Building Inspections - RE: 42 Seal Cove Ln.

The owner made some changes to the plan and we are filing the attached amended set of plans.

**S2-001**

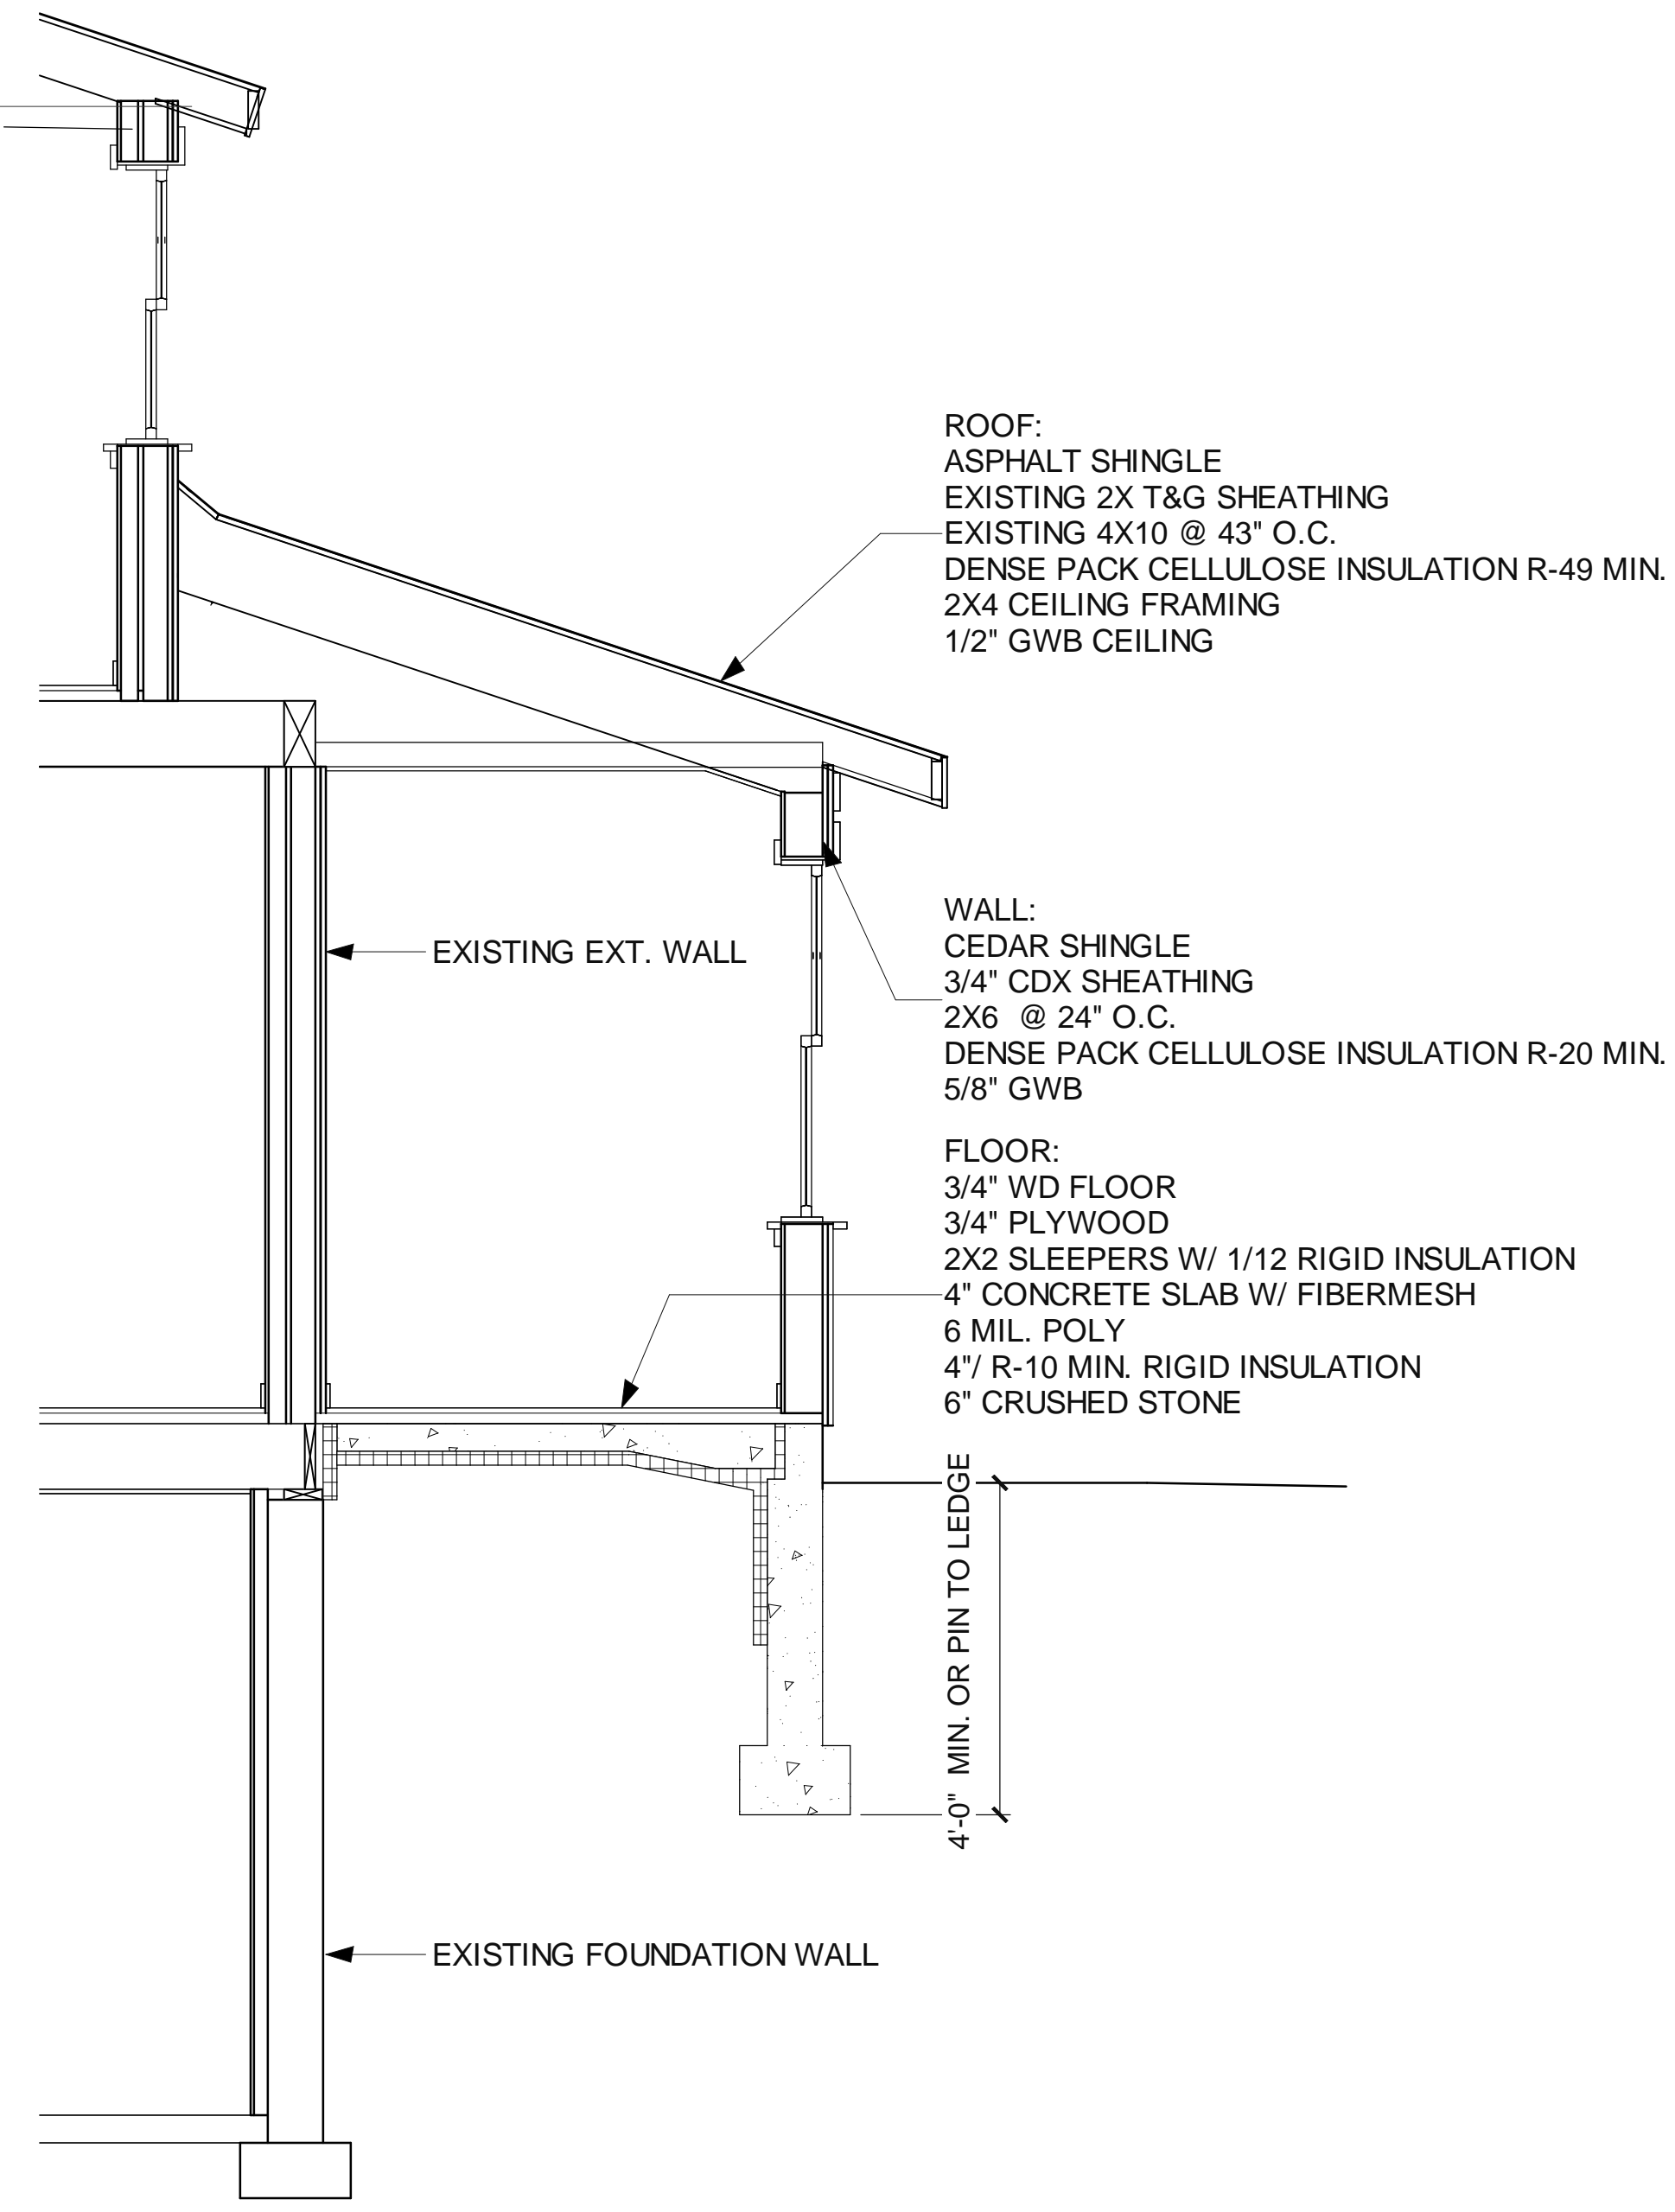
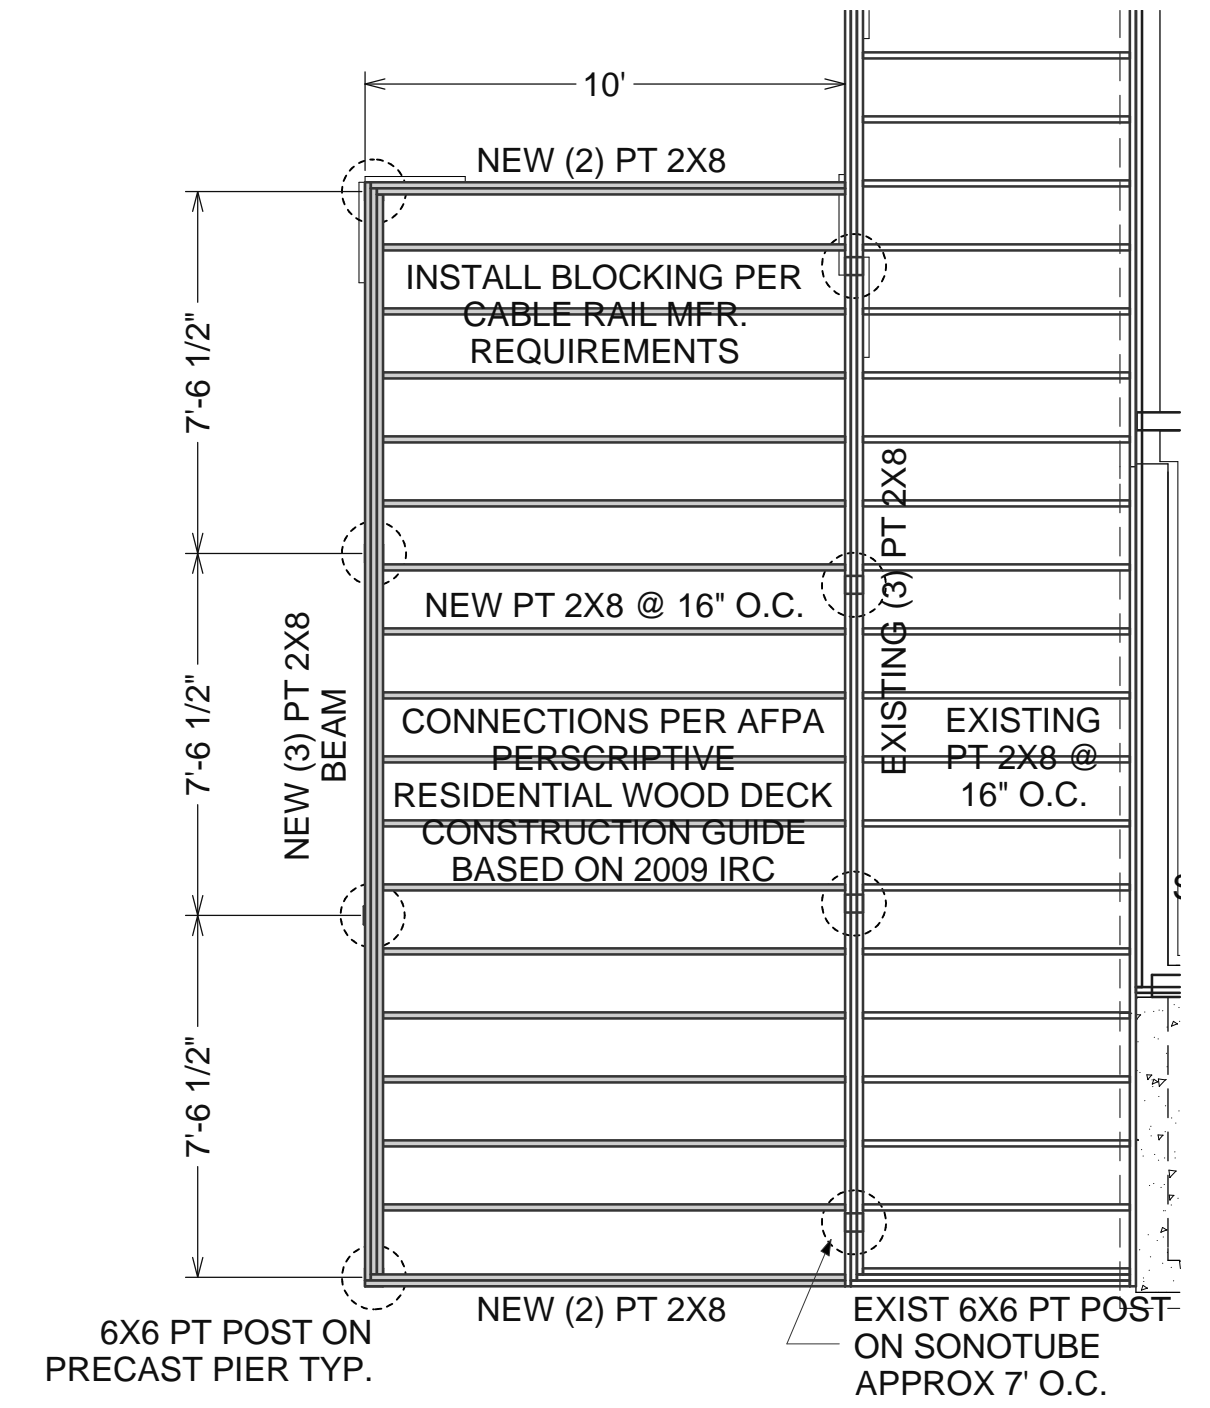
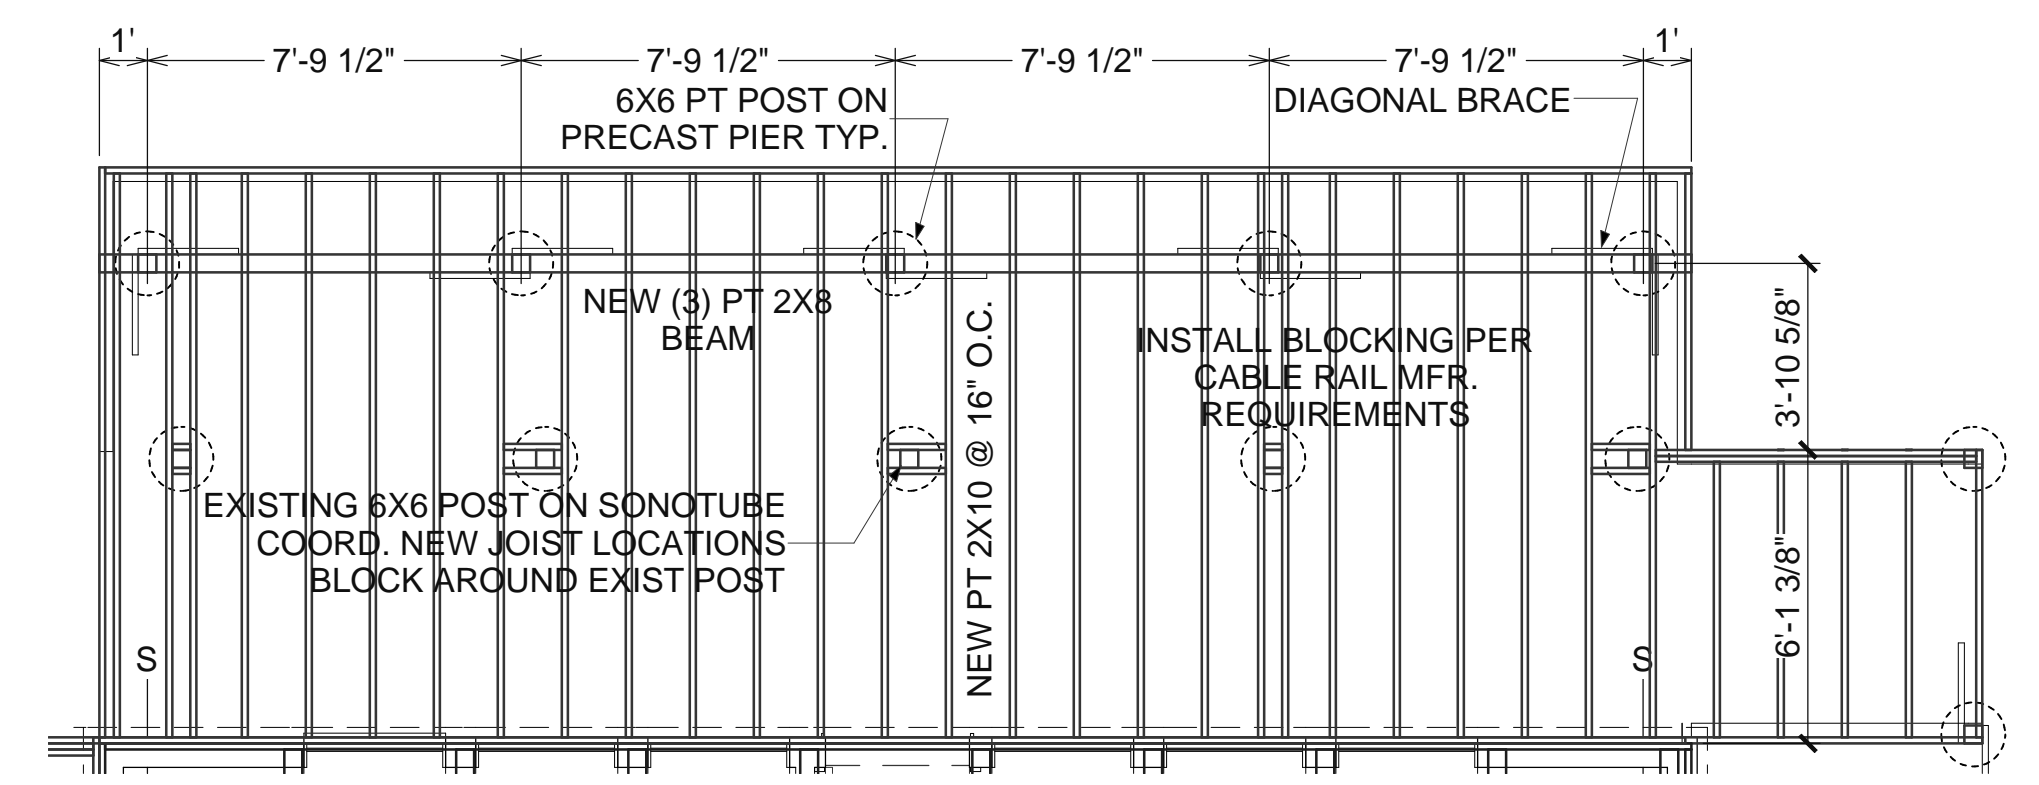
We are missing some framing details, see attachments.

The answer to your deck framing questions are on the new S2-001.
